## Fire Marshal Division

**Re: Town of Lillington Fall Fest**  
**106 W. Front St.**  
**Lillington, NC 27546**

**Application Number FMFW1906-0005**

Diagram for Lillington Fall Festival 2019

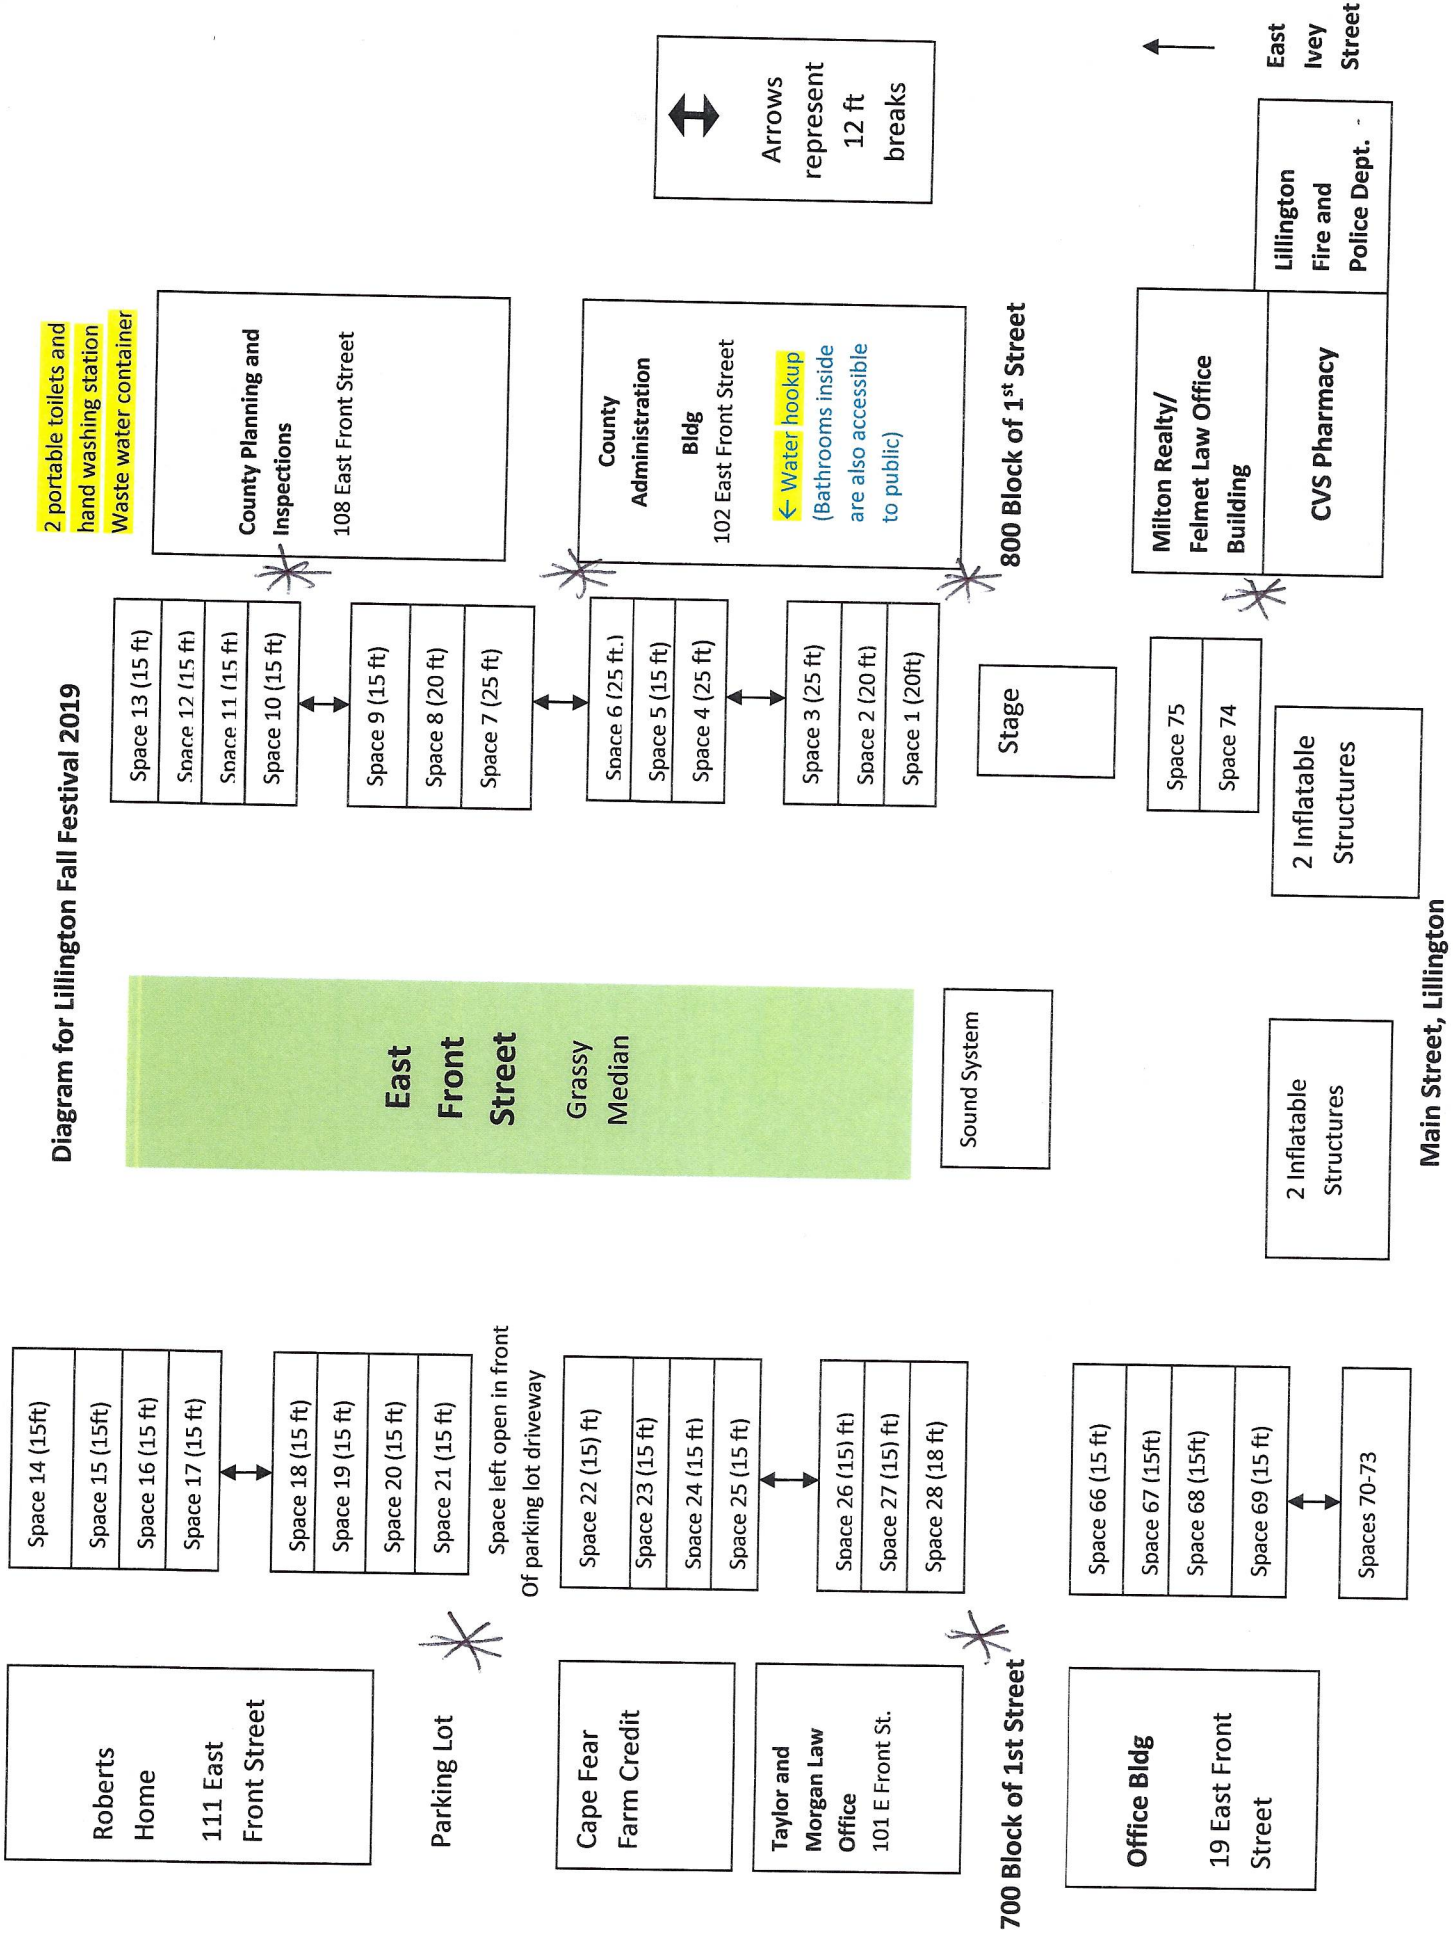
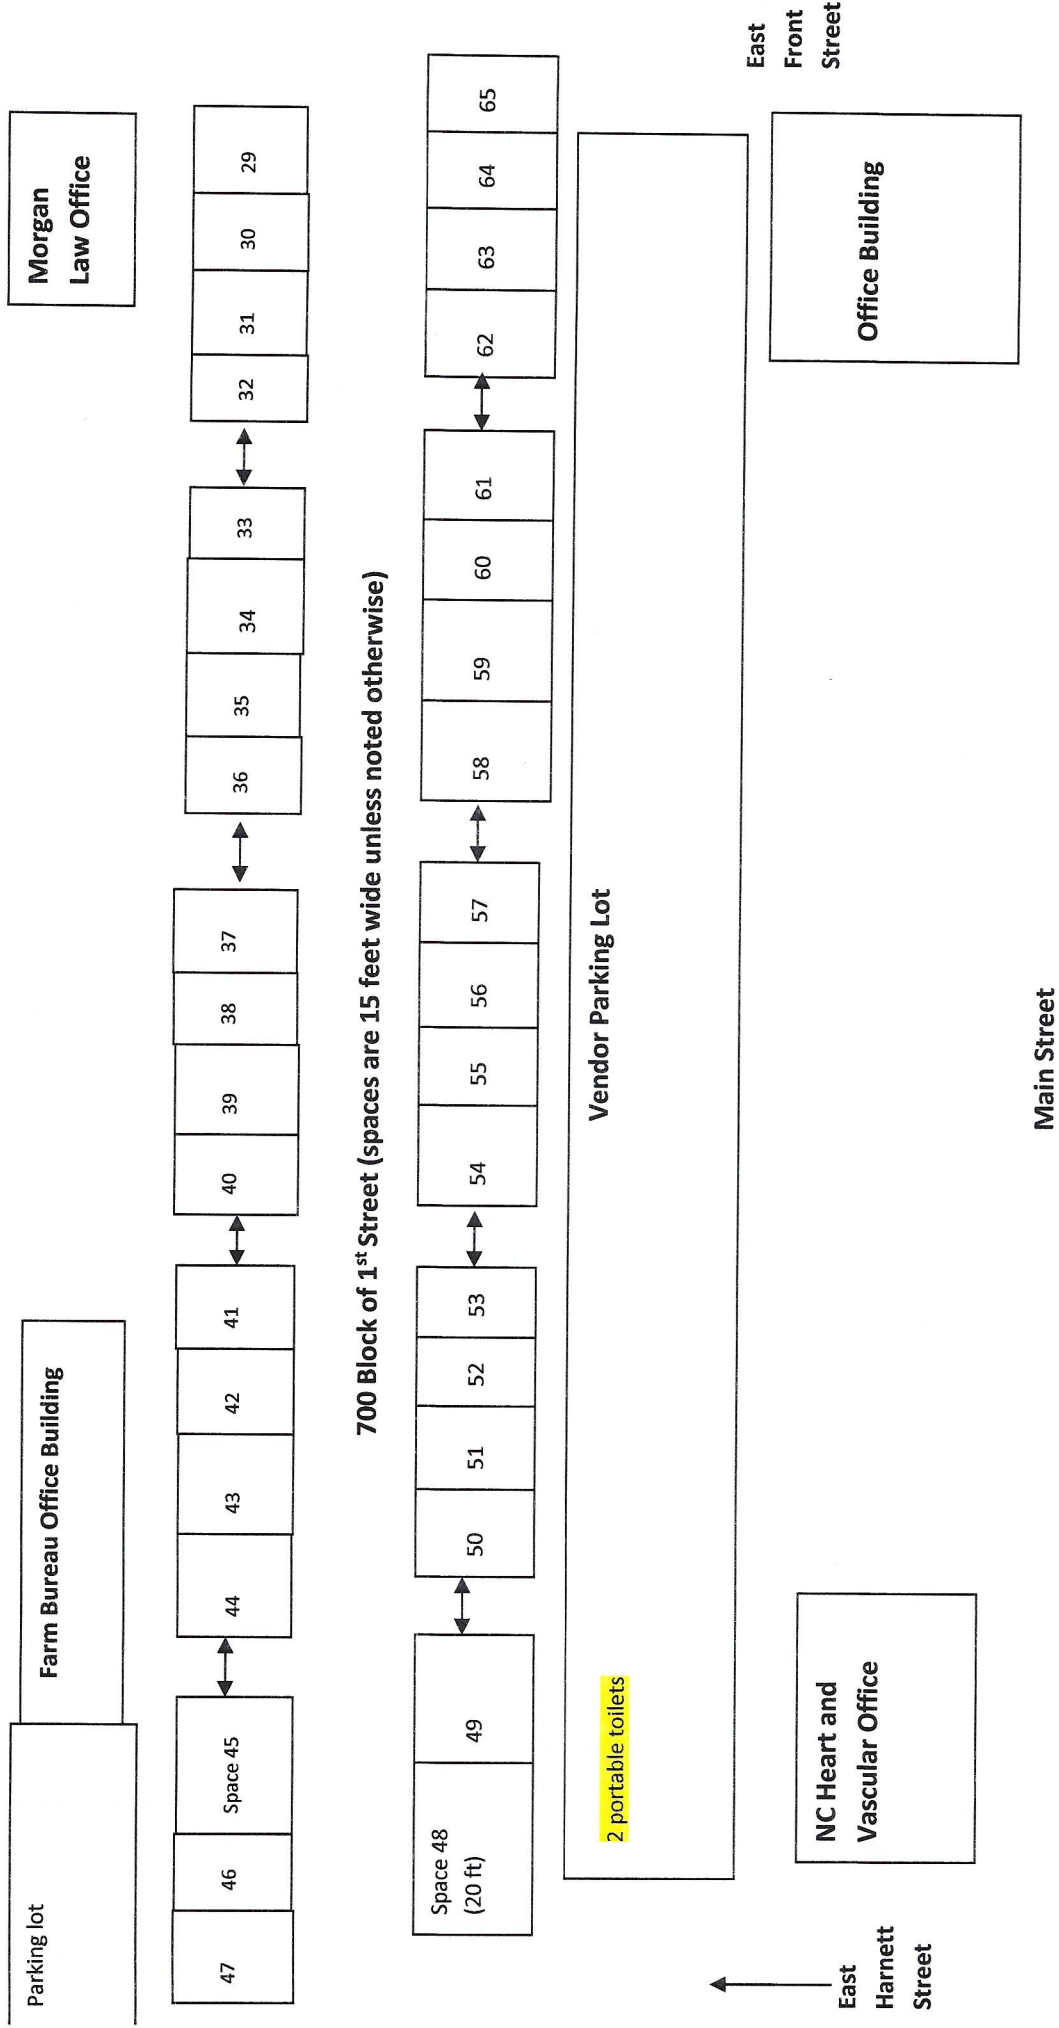
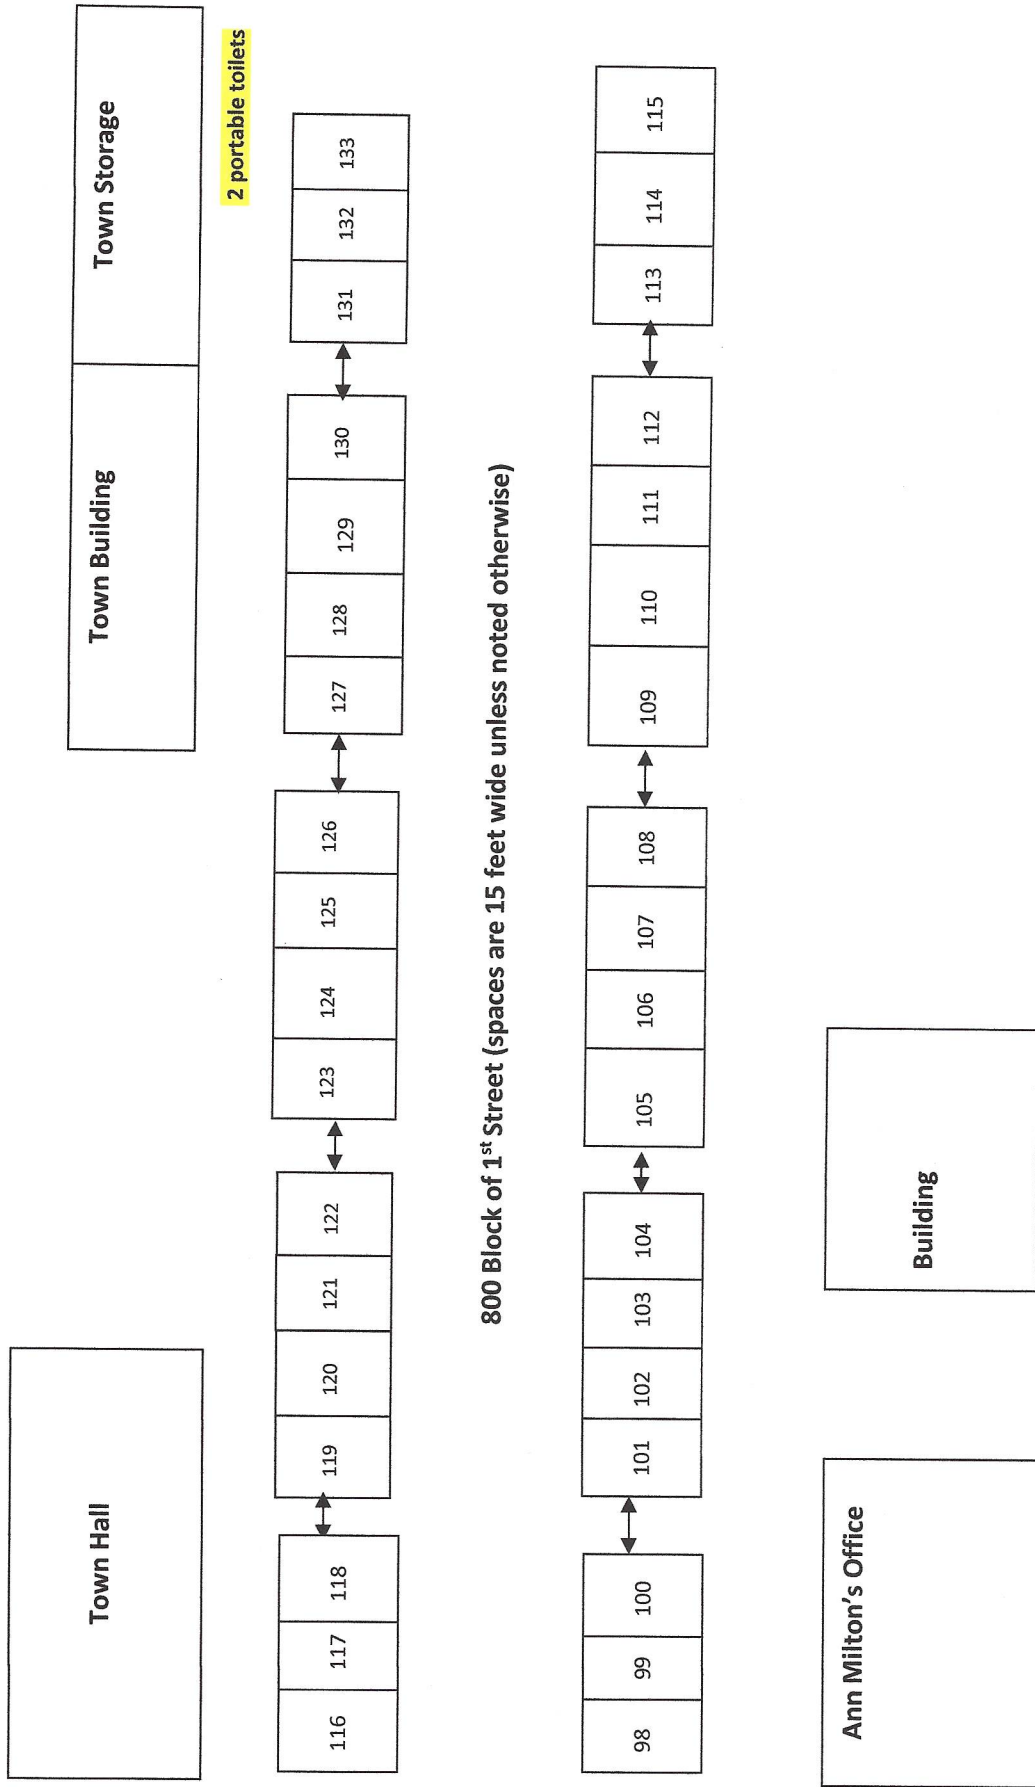
- **Permits**
  - A permit will be issued for the special assembly that will include the event as a whole.
  - A permit may be issued for other tent areas if the individual tent exceeds 800 square feet or the aggregate area of multiple canopies placed side by side without a fire break clearance of 12' exceeds 1800 square feet.

- **Fire Extinguishers**
  - Portable fire extinguishers shall be provided within a 30-foot (9144 mm) travel distance of commercial-type cooking equipment. Cooking equipment involving vegetable or animal oils and fats shall be protected by a Class K rated portable extinguisher.
  - 2A-10B:C fire extinguisher shall be placed at tents/canopies with a travel distance not to exceed 100' from any fire extinguisher

- **2411.6 Outdoor cooking.**
  - Outdoor cooking that produces sparks or grease-laden vapors shall not be performed within 20 feet (6096 mm) from a tent, air-supported, air-inflated or tensioned membrane structure, temporary membrane structure or canopy

- **2415 Generators**
  - Generators and other internal combustion power sources shall be separated from tents, air-supported, air-inflated or tensioned membrane structures, temporary membrane structures or canopies by a minimum of 20 feet (6096 mm) and shall be isolated from contact with the public by fencing, enclosure or other approved means.

- **2413.3 Refueling.**
  - Refueling shall be performed in an approved location not less than 20 feet (6096 mm) from tents, air-supported, air-inflated or tensioned membrane structures, temporary membrane structures or canopies.

- **2406.4 Combustible materials.**
  - Hay, straw, shavings or similar combustible materials shall not be located within any tent or air-supported structure containing assembly occupancy, except the materials necessary for the daily feeding and care of animals. Sawdust and shavings utilized for a public performance or exhibit shall not be prohibited provided the sawdust and shavings are kept damp. Combustible materials shall not be permitted under stands or seats at any time. The areas within and adjacent to the tent or air-supported structure, shall be maintained clear of all combustible materials or vegetation that could create a fire hazard within 20 feet (6096 mm) from the structure. Combustible trash shall be removed at least once a day from the structure during the period the structure is occupied by the public.
